From: Dominic Smith [REDACTED]
Sent: 03 September 2015 09:50
To: Planning.Responses
Subject: RE: Planning Consultation on: BN/26/15/RES

**WEST SUSSEX COUNTY COUNCIL
STRATEGIC PLANNING CONSULTATION**

SUBJECT: Approval of reserved matters following outline consent BN/7/12/ for 44 No. dwellings including 30% affordable, comprising of a mix of 2 & 4 bed houses with associated landscaping & works. This application is a Departure from the Development Plan.

Land North of Yapton Road and East of Garden Crescent, Barnham, PO22 0AR

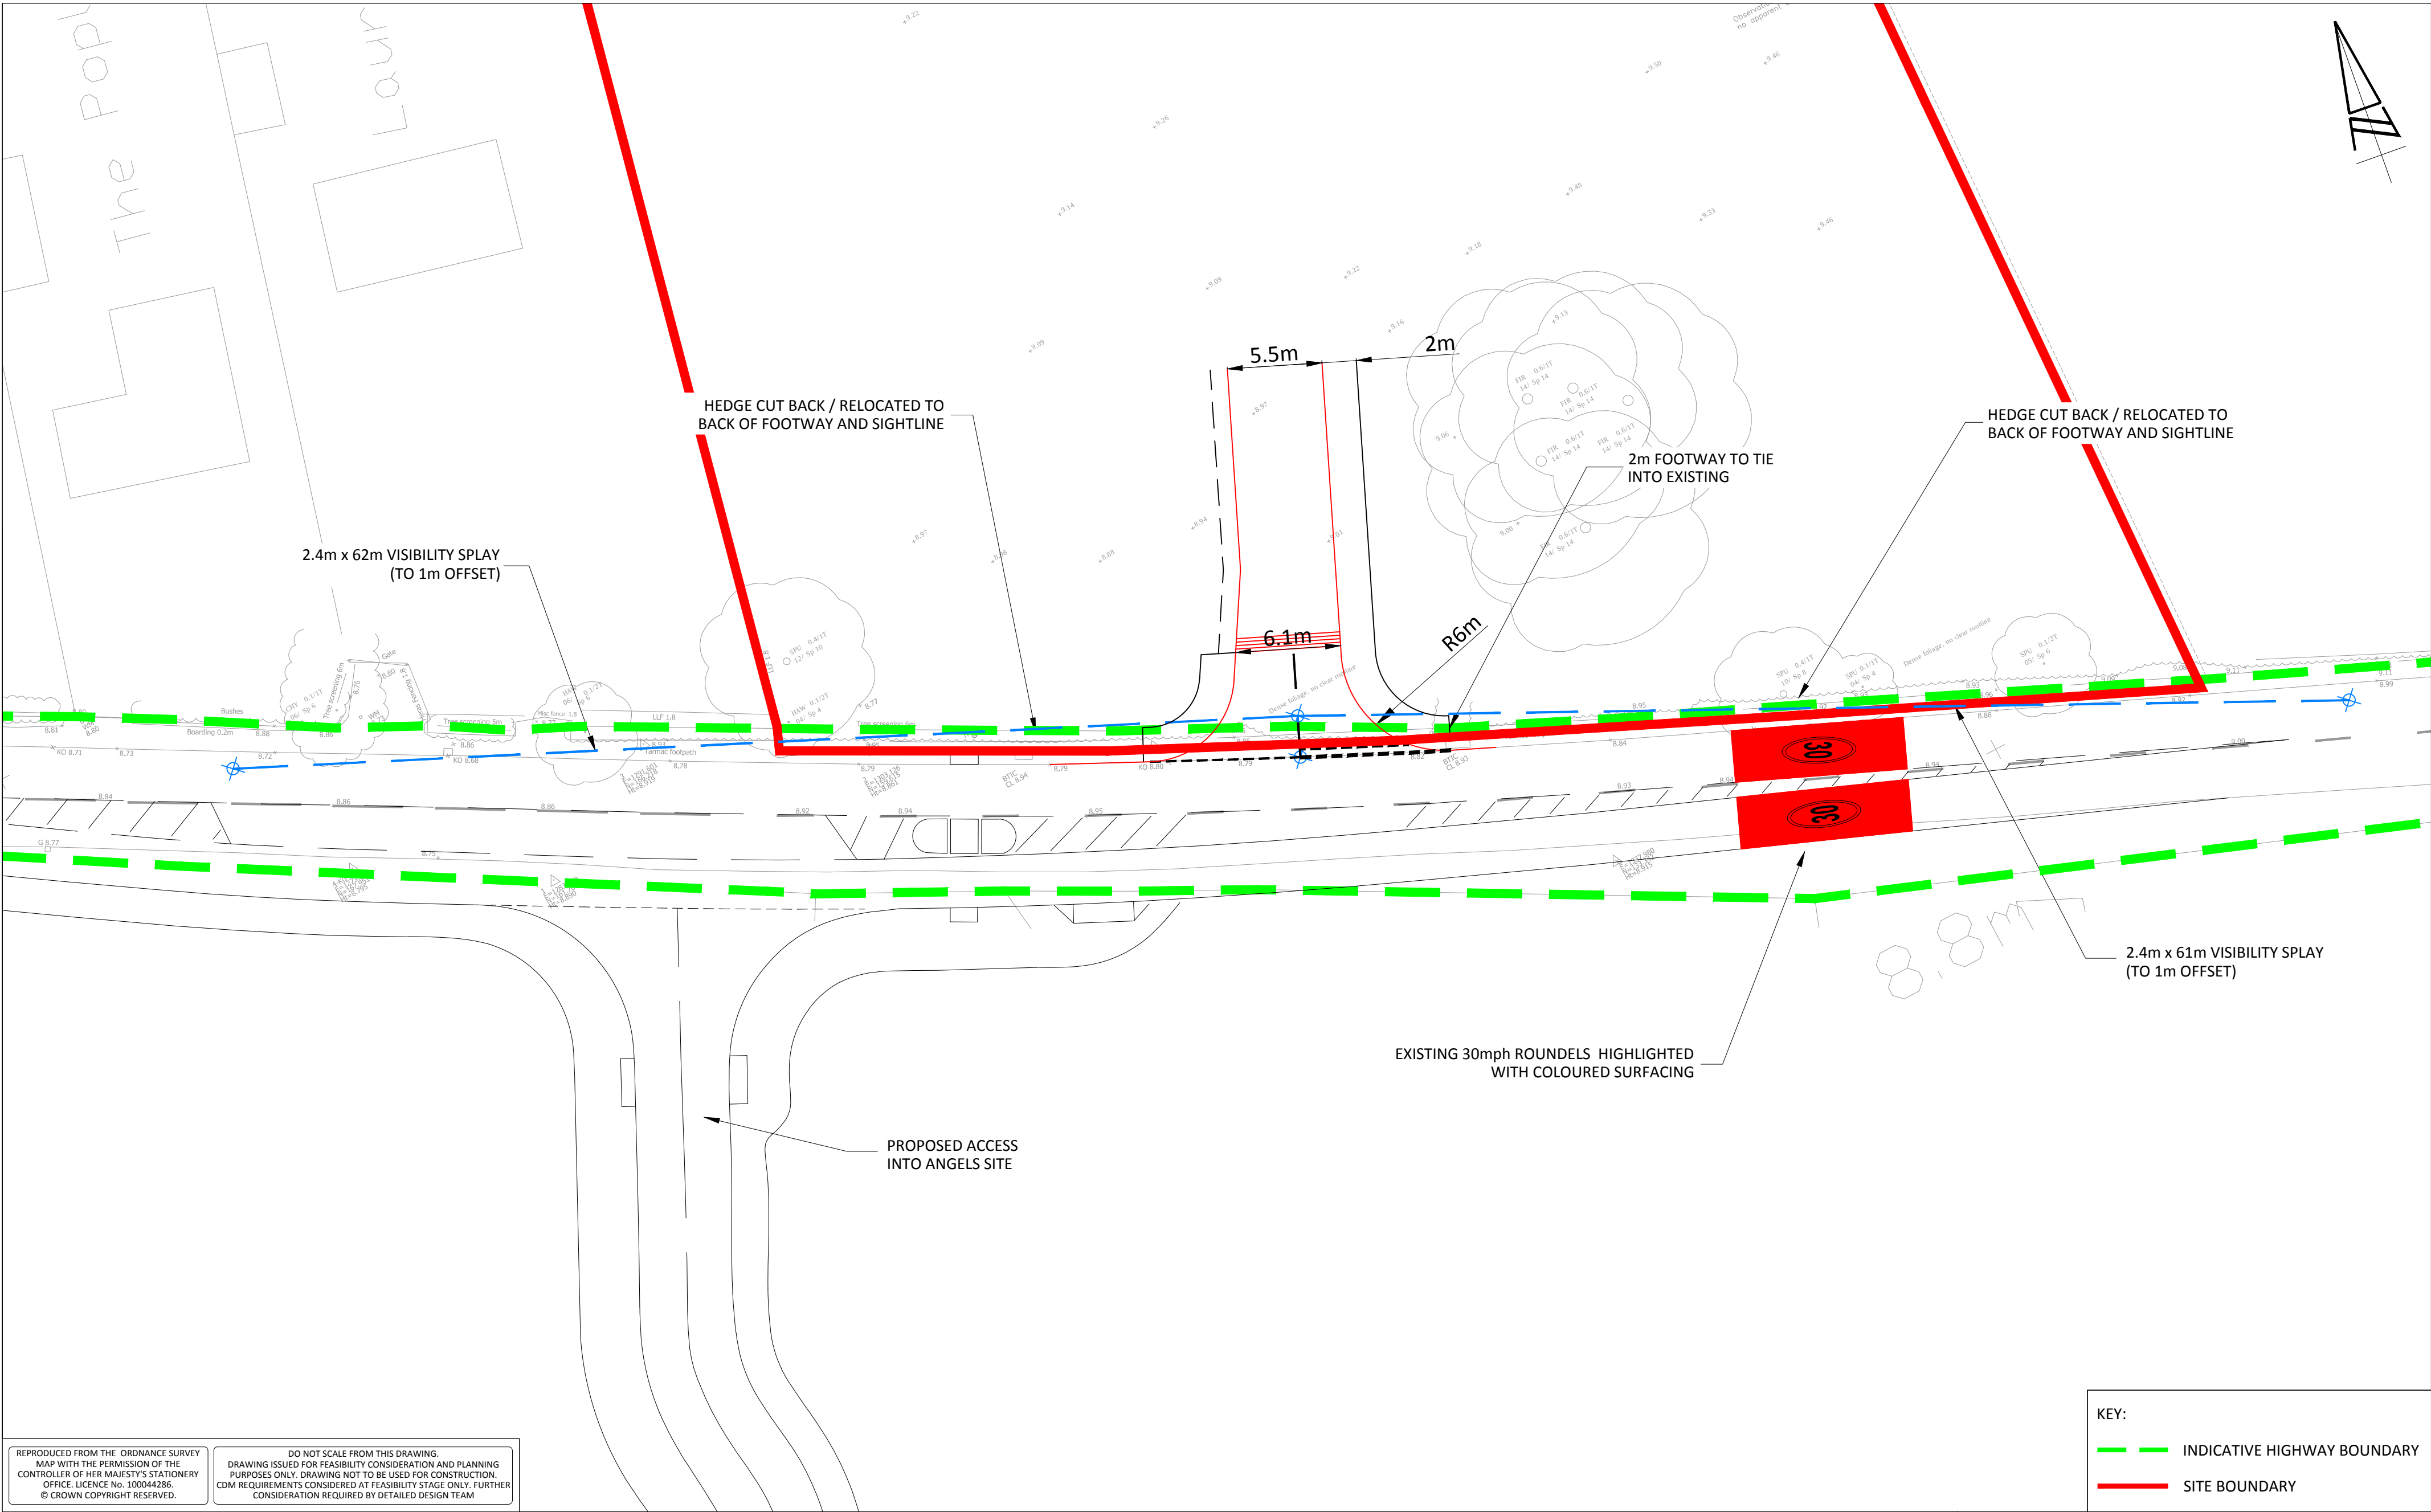
In order to determine the required visibility splays, the speed data collected as part of the outline planning application has been re-used. The 85th percentile speeds were measured at 38.4mph eastbound and 38.3mph westbound. Suitable visibility splays of 62m and 61m respectively have been agreed to a 1m offset and are as shown on drawing ITB10358-GA-005 Rev E.

Roundels and coloured surfacing have been shown on the access drawing. These are not considered necessary to facilitate safe access as the visibility required for the recorded 85th percentile speeds can be achieved. Further consideration of their provision should be considered through the Section 278 process in consultation with WSCC Asset Management.

The previous access arrangement included 2m footways on either side of the access road. However, this will now only be provided on the eastern side to accommodate pedestrian movements to/from the east. Movements to/from the west will be catered for with a 3m footway/cycleway link to the west of the site connecting to Crescent Gardens. This is considered to be acceptable; the existing condition should be amended to reflect the new plan reference and alteration to the visibility splay distances.

**Soft Landscape Layout
Residential Planting Proposals**

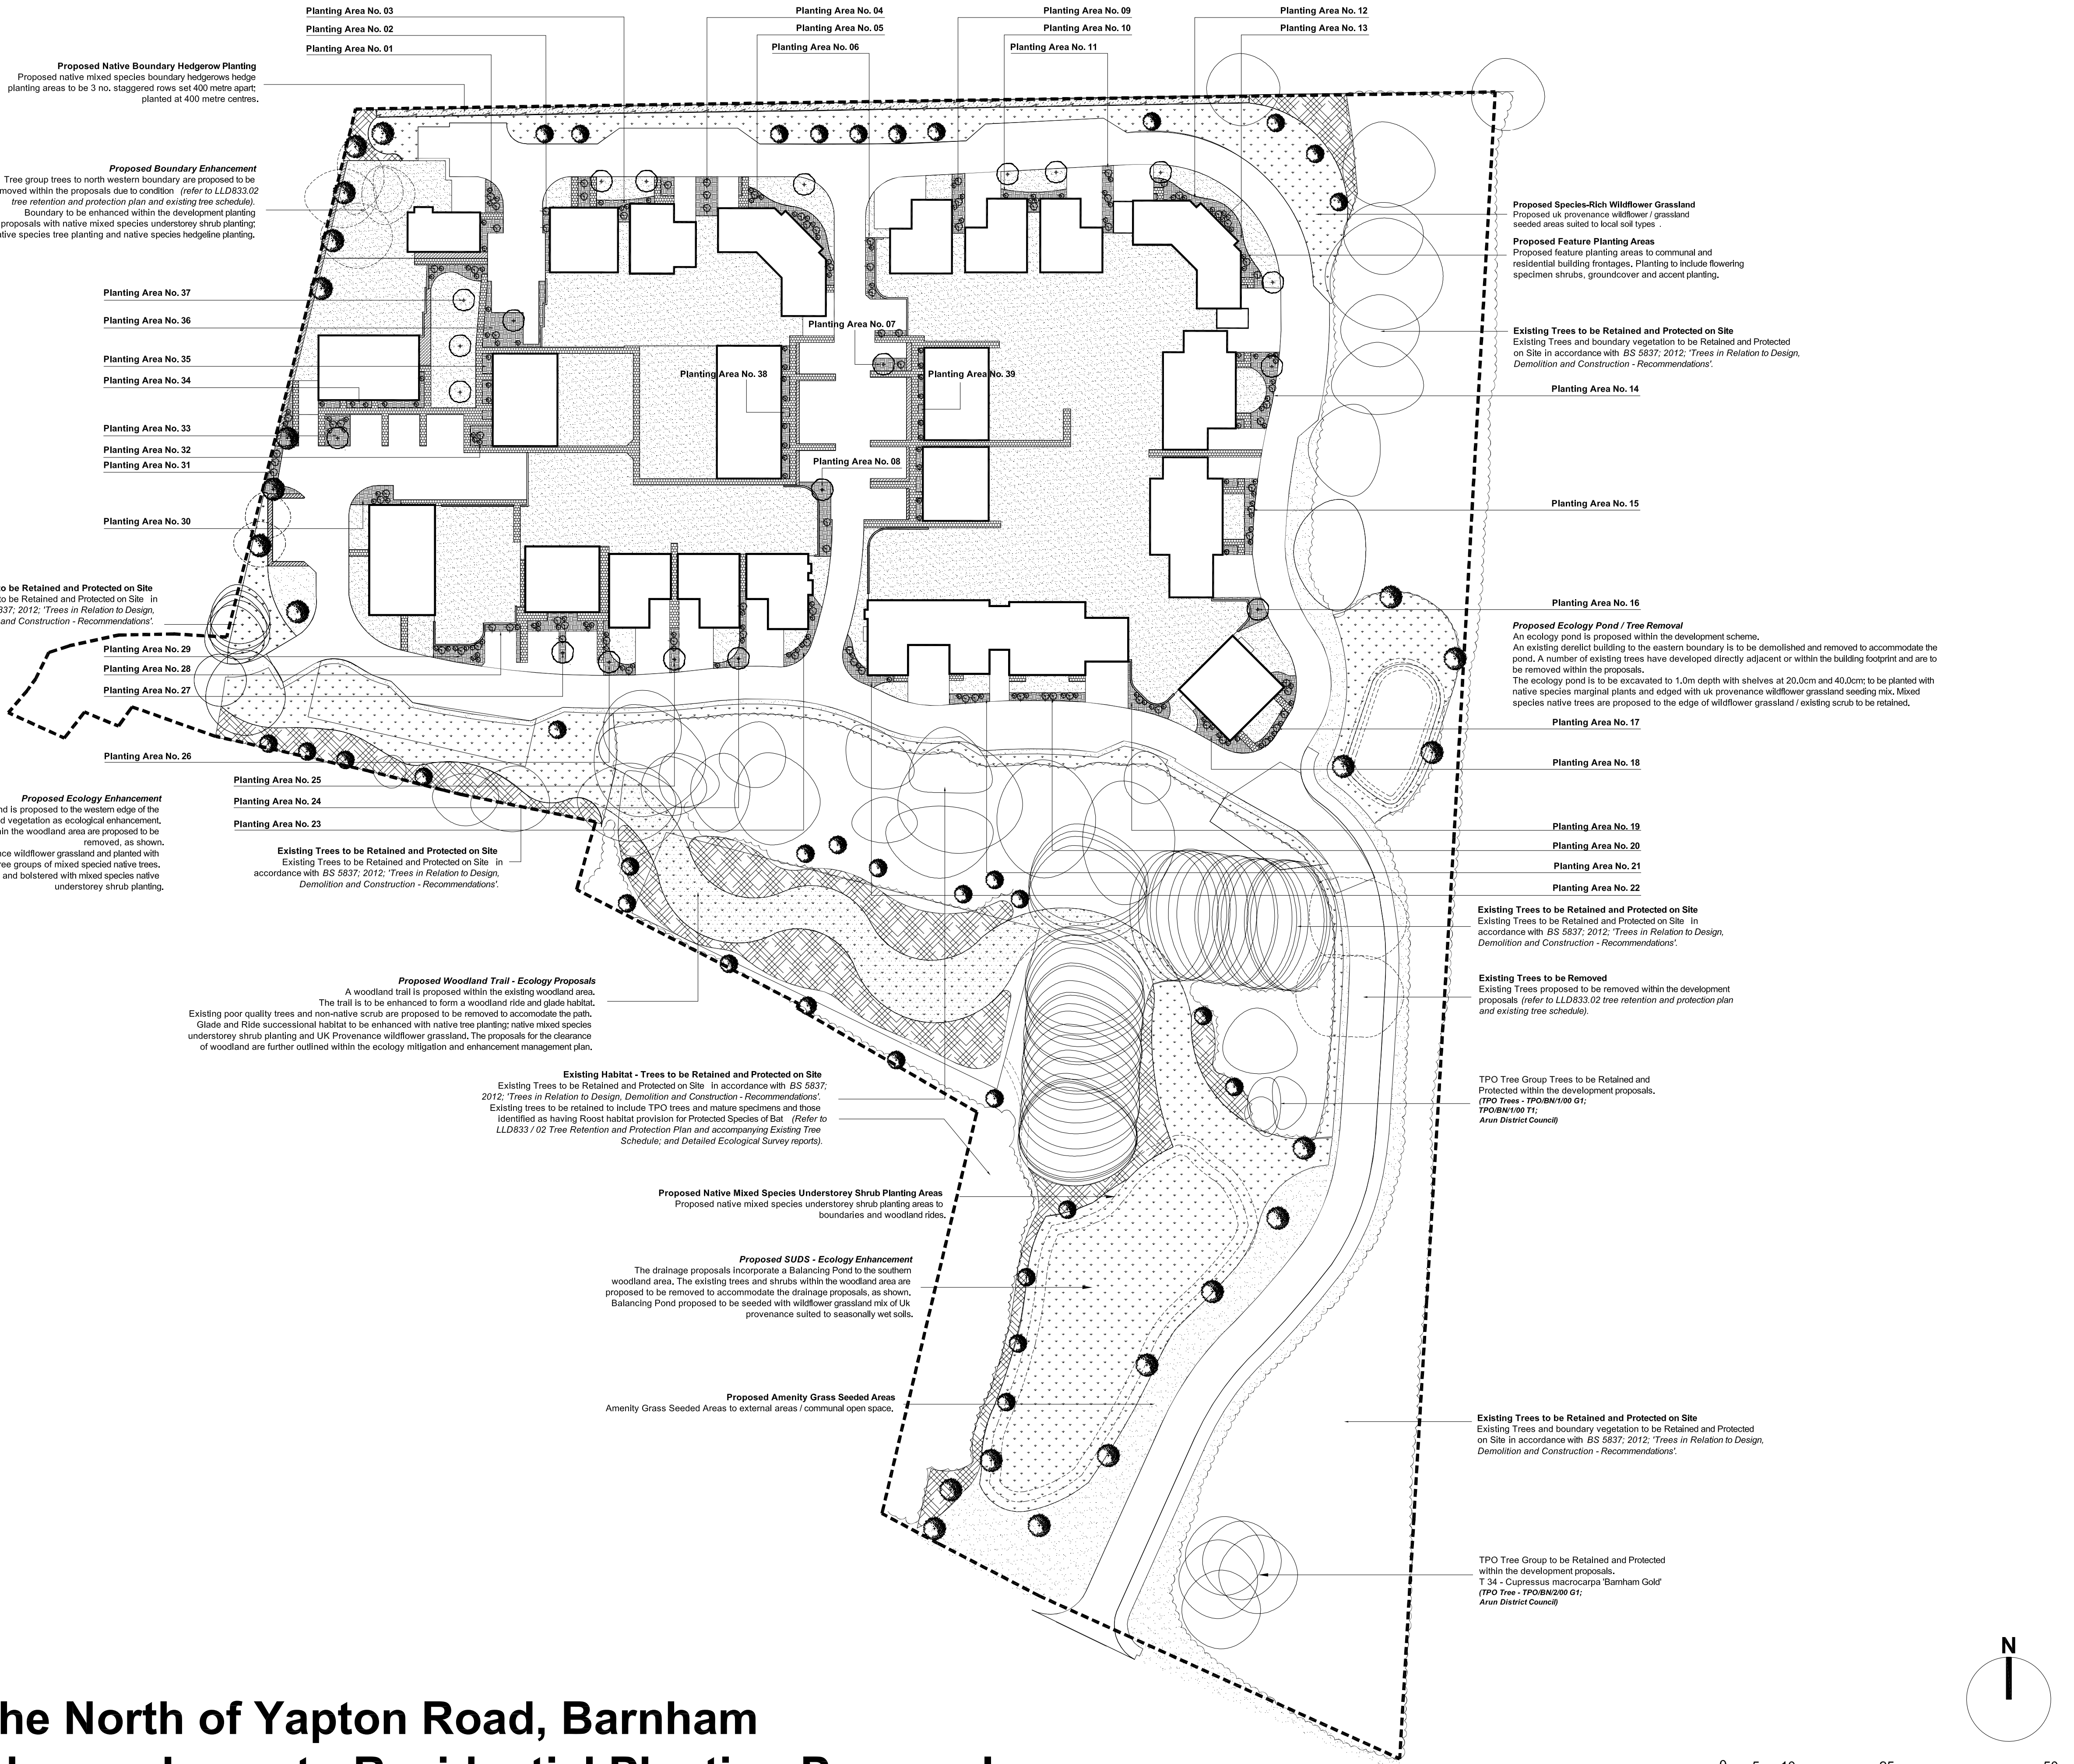
It is recommended that landscaping adjacent to the carriageway, particularly at junctions and on the bend on the access road is set back a minimum of 2m from the edge of the carriageway to provide a service margin and maintain visibility. Any landscaping directly adjacent to the carriageway should be kept below a height of 600mm to maintain visibility.
